Sandra Mullett from GREAT MOULTON

LIST OF ISSUE-SPECIFIC QUESTIONS – SUBMISSION REFERENCE SBCAF9C09

Sources: Esri, TomTom, Garmin, FAO, NOAA, USGS, © OpenStreetMap contributors, and the GIS User Community

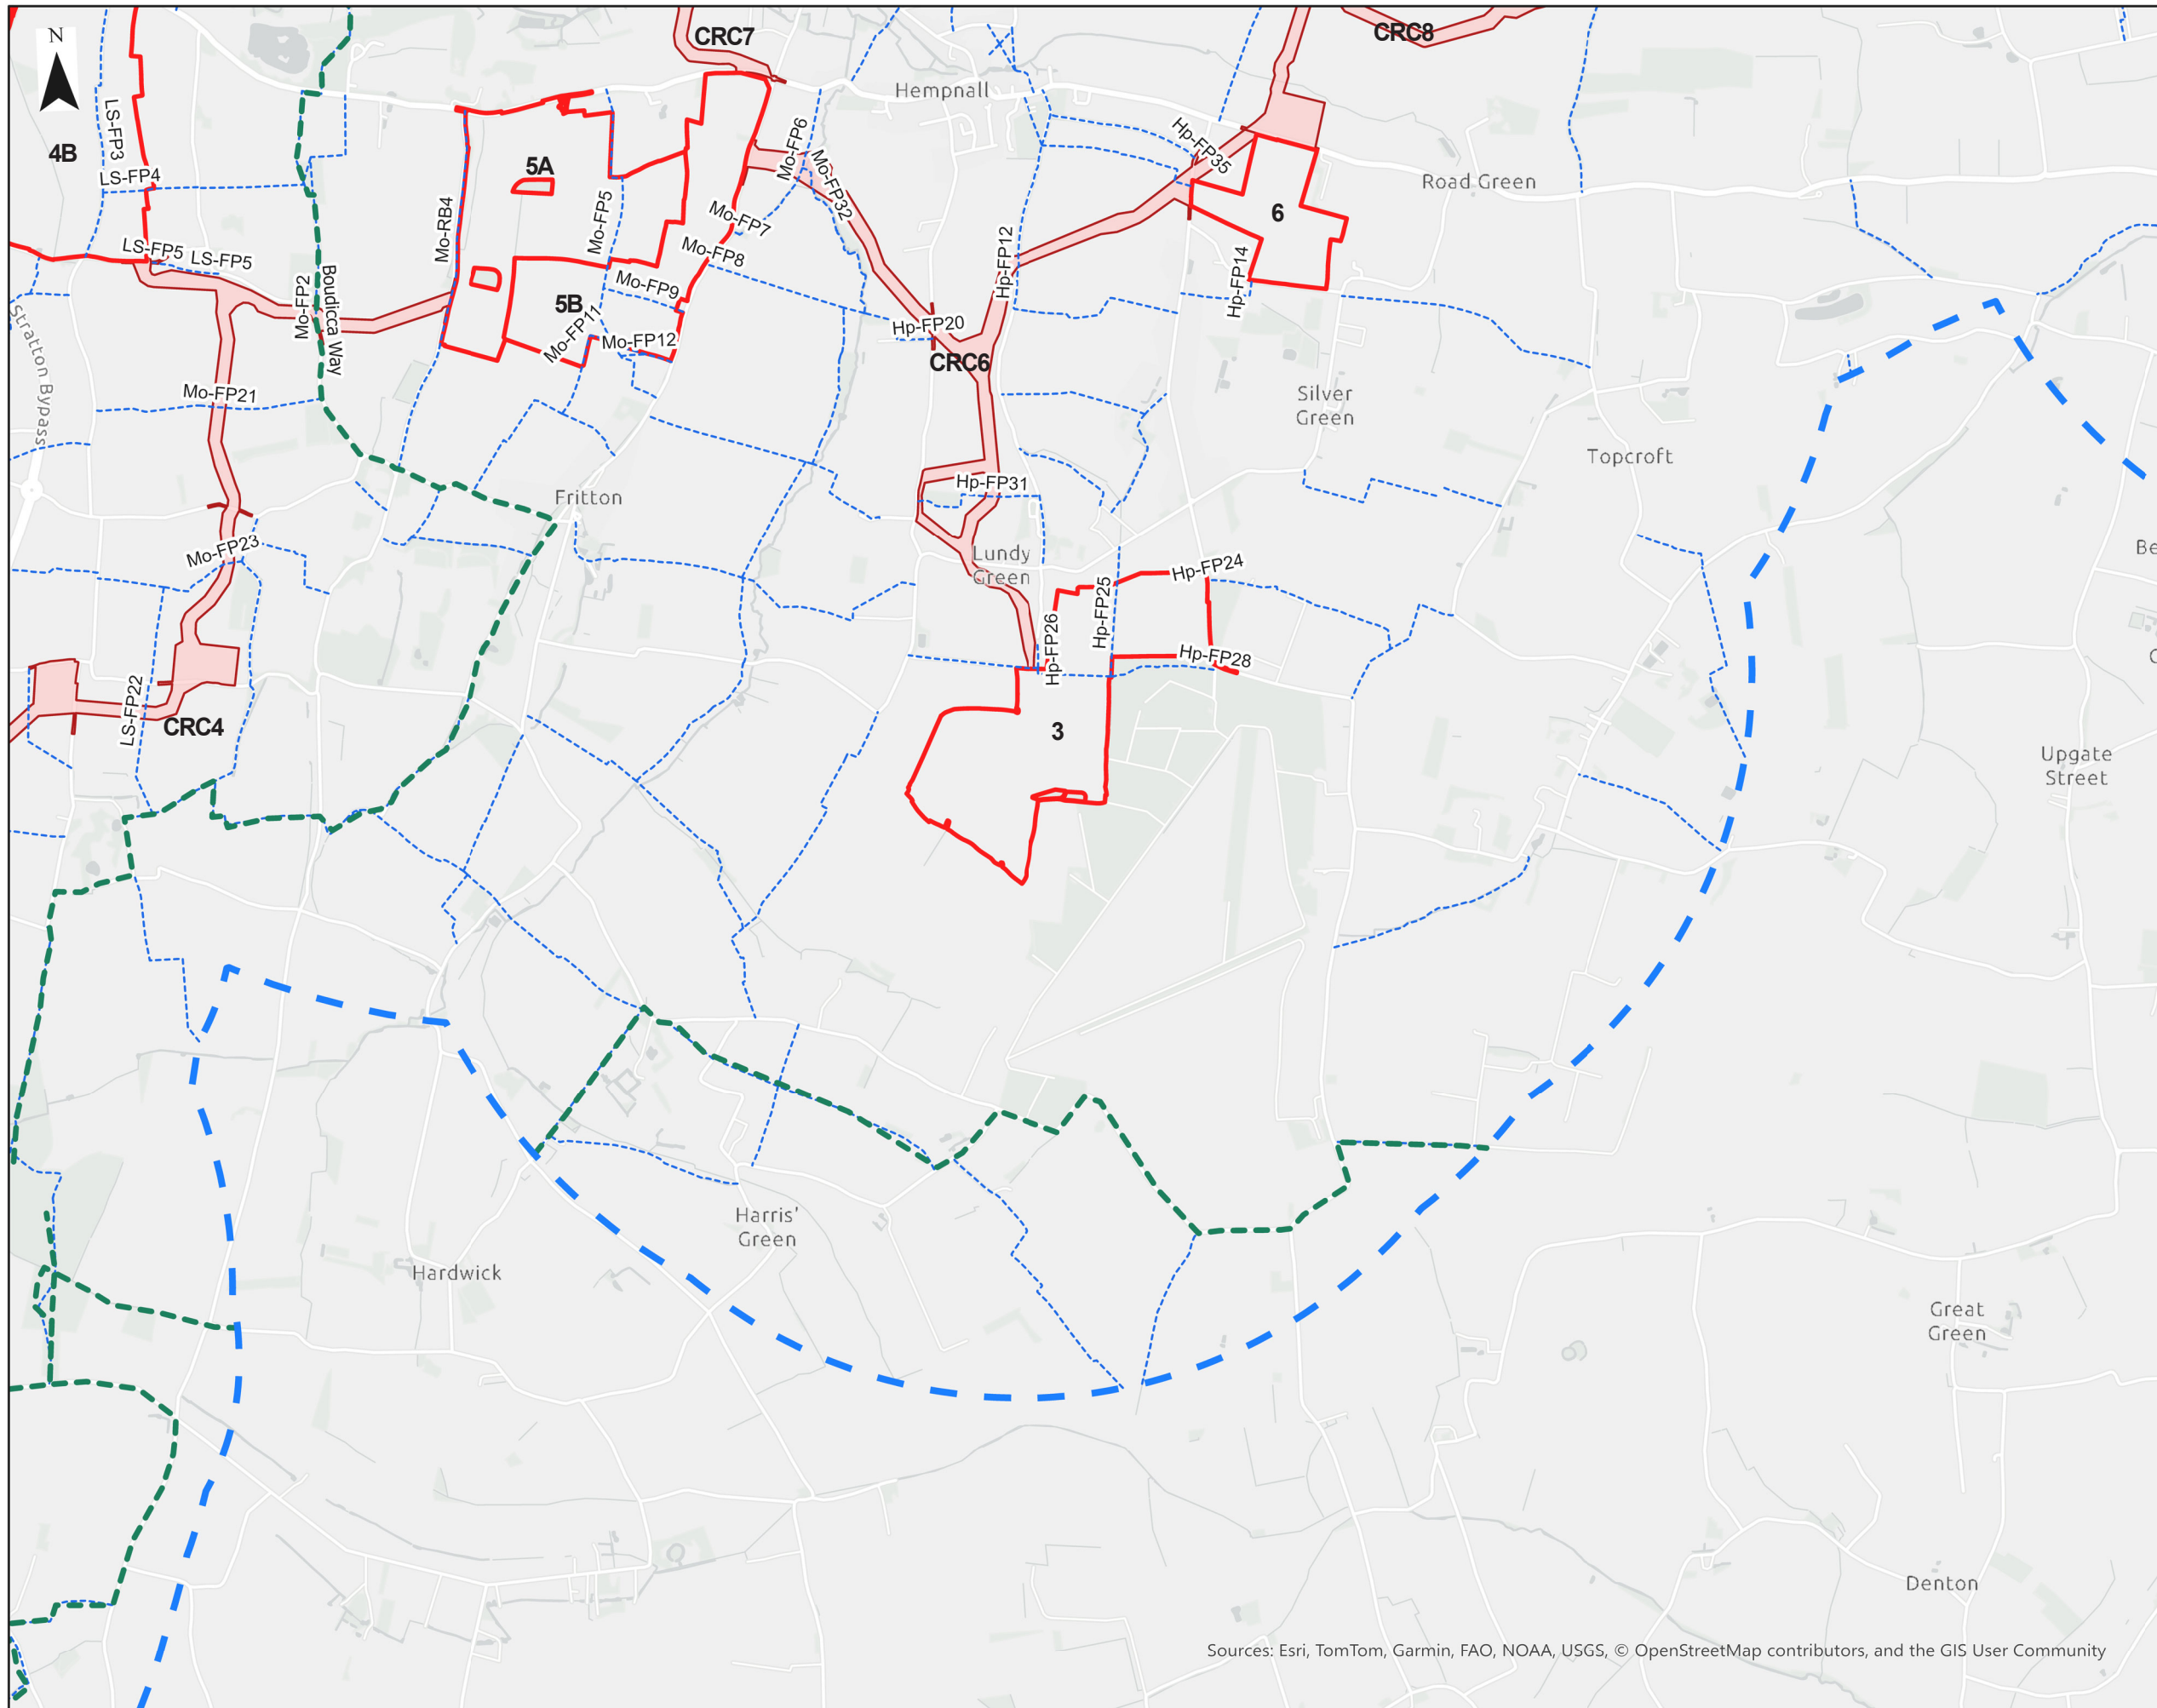
3. Hundred Lane/RB19 – Permanent Haul Route and Maintenance Crossing

- i. What changed between the PEIR access strategy and the final DCO design to make a permanent engineered crossing of Hundred Lane/RB19 is now necessary?
- ii. Why can A03/Frith Way and the previously identified Lodge Road/Frith Way arrangement not meet the operational needs, whether by continued use, adaptation or shared accesses?
- i. What alternatives were considered specifically for the Hundred Lane crossing, and where is the comparison showing that reasonable alternatives would not avoid or materially reduce the acknowledged Significant harm to RB19?
- iii. When was the permanent Hundred Lane crossing first added into the Scheme design, and where and when were affected residents and users of RB19 clearly consulted about the haul-route crossing remaining as permanent maintenance access?

3.2 If the crossing is intended to remain after Year 60 to serve the National Grid Substation or Grid Connection Infrastructure, **why is that potentially indefinite effect not been clearly identified and assessed as permanent infrastructure associated with the retained transmission asset?**

Before the Hundred Lane crossing be authorised as a permanent infrastructure, The Applicant should set out why it is operationally necessity, the vehicle types, likely frequency of use, exact width and surfacing, and why the same function cannot be achieved through existing access points?
